Search application details

Application number: 2026/92233	
What is the application for?:	Erection of two storey and single storey rear extensions
Address of the site or building:	1, Amberwood Chase, Shaw Cross, Dewsbury, WF12 7NZ
Postcode:	WF12 7NZ

PROPOSED SITE PLAN

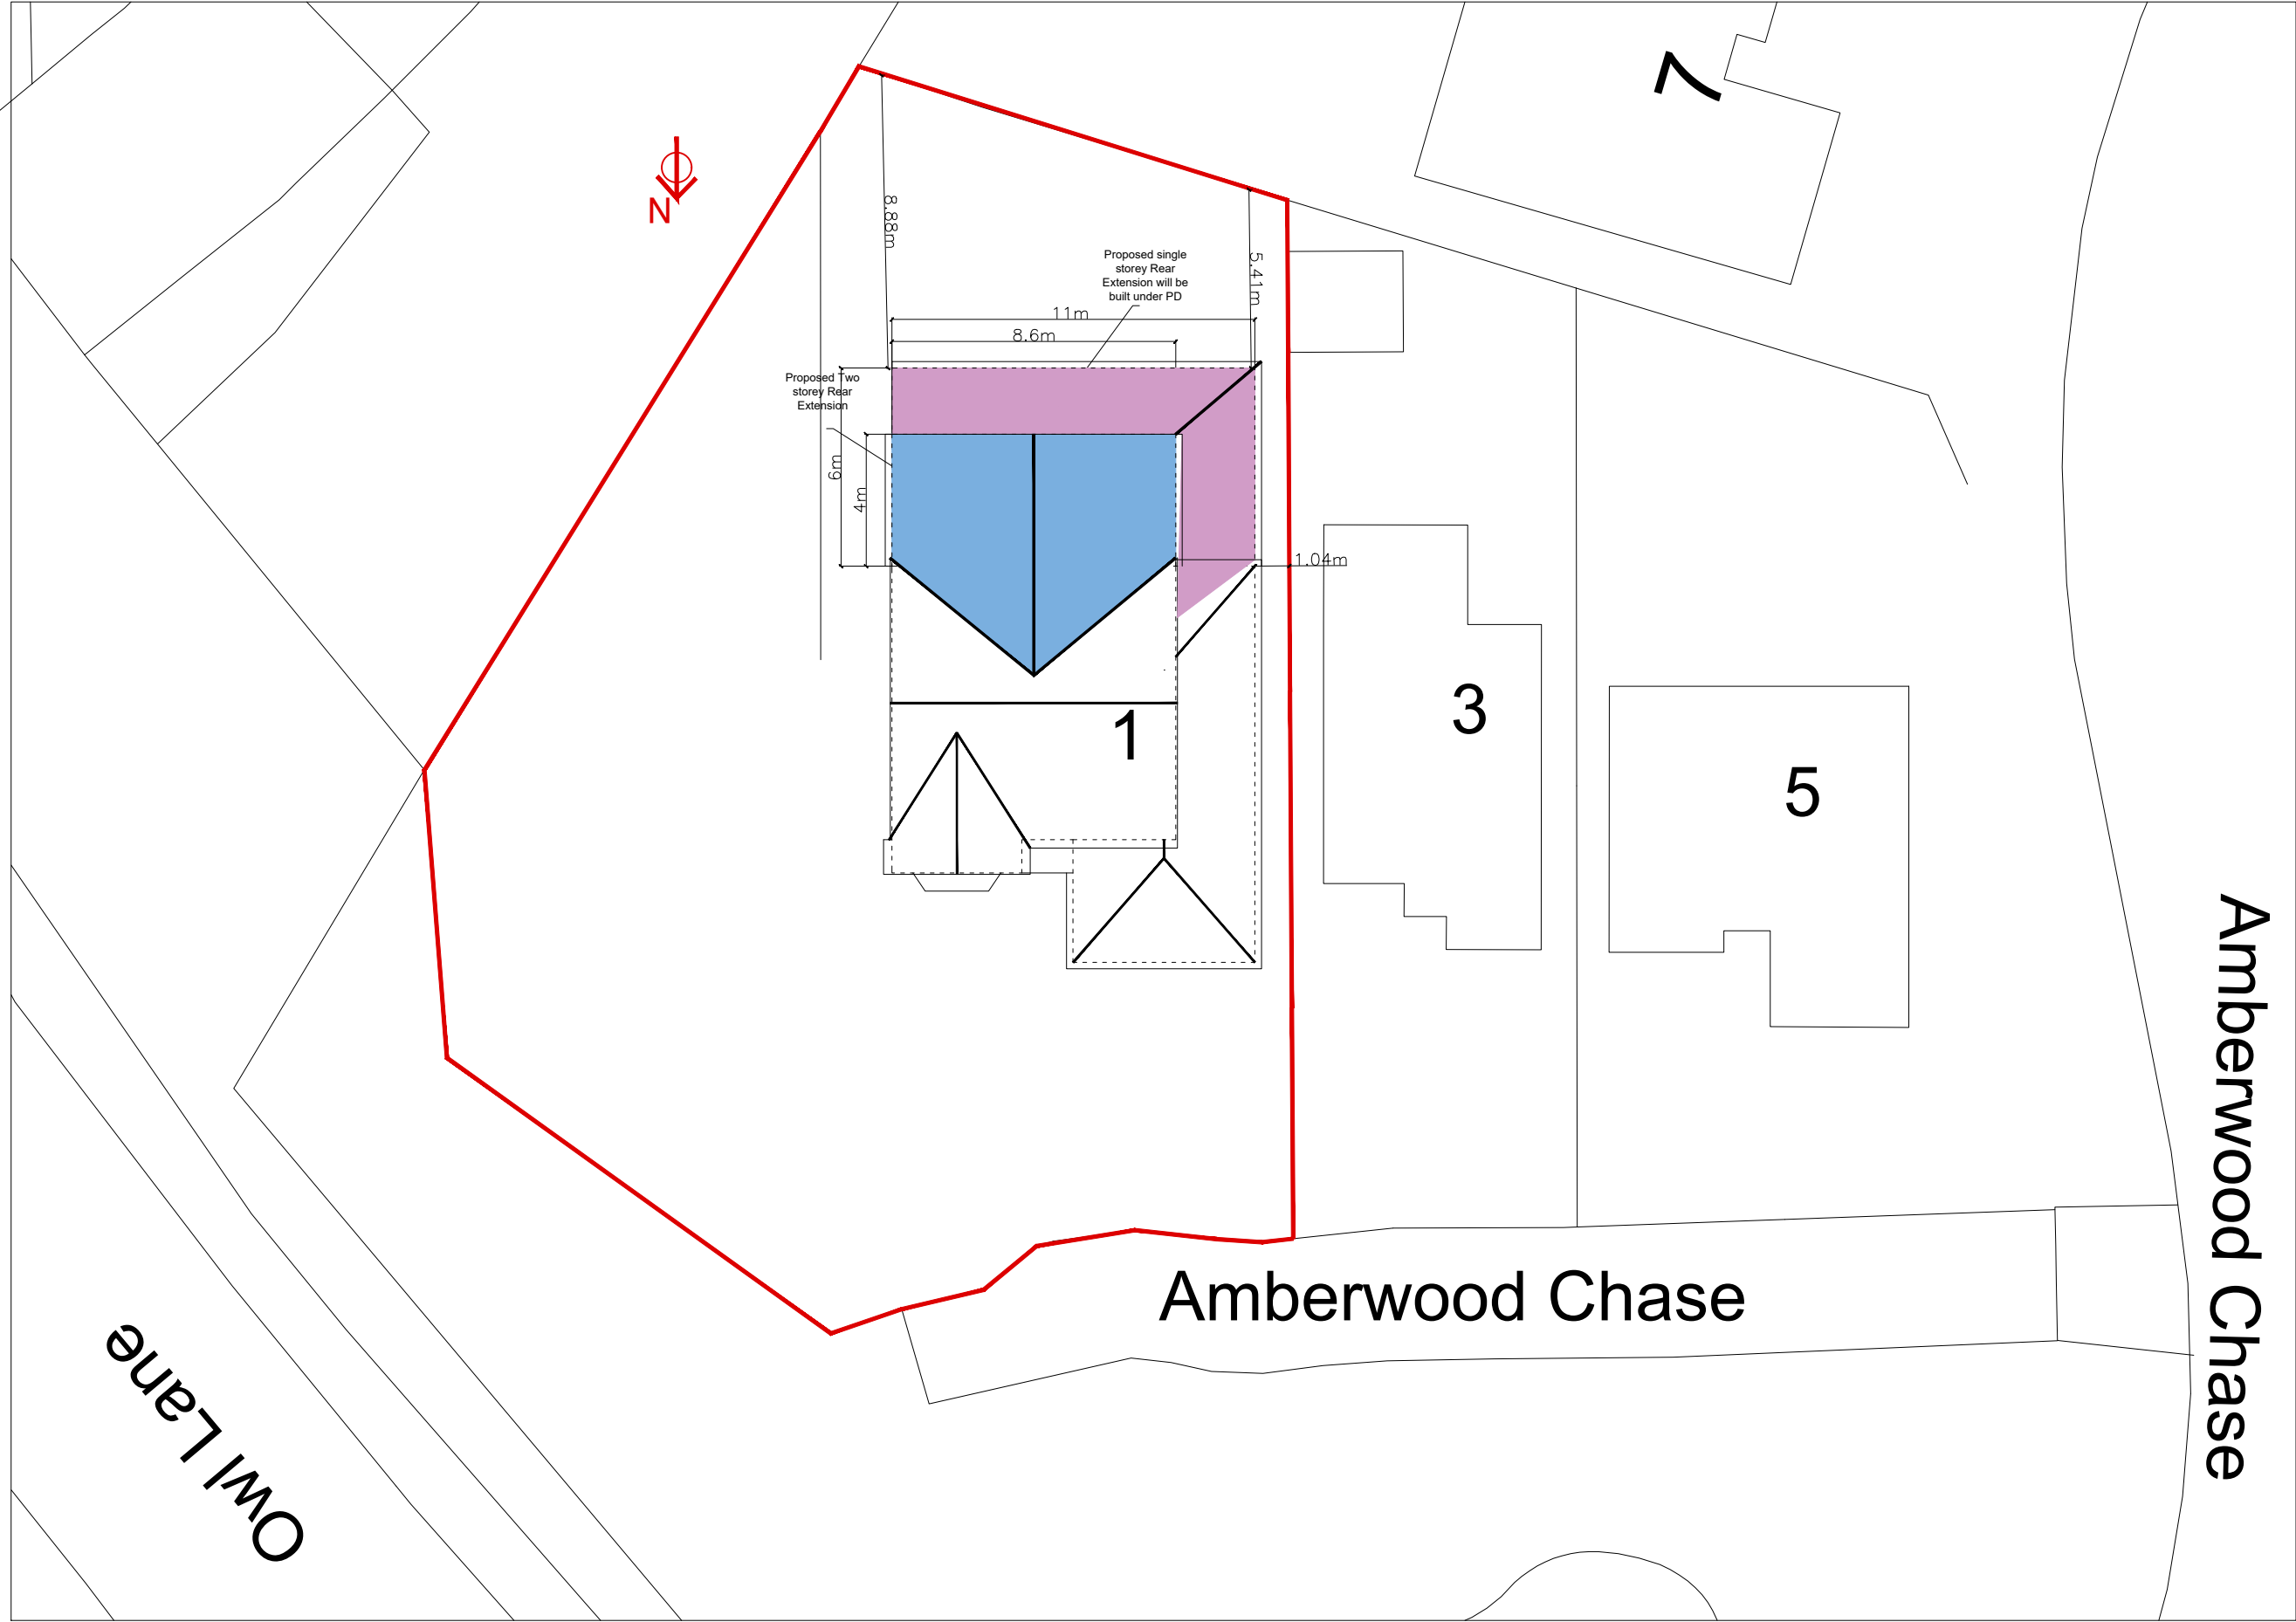
Type of comment: An objection	
Do you wish your comments to be published on the website anonymously?	Yes
The site plan with the application show site boundary that are not in line with true property boundaries with fences. The proposed extension will be very close to the rear fence. The proposed extension is very large increase in the current footprint of house and a massive % loss of their garden (based on actual fence line not the inaccurate larger boundary shown). The boundary shown on drawings is actually covering large shared public areas that the maintenance is paid for by the housing estate management group. Any application should be based on true and accurate drawings not incorrect information. It should be noted that the application signage displayed on the road has only just arrived to notify residents which does not allow very long for residents to comment.
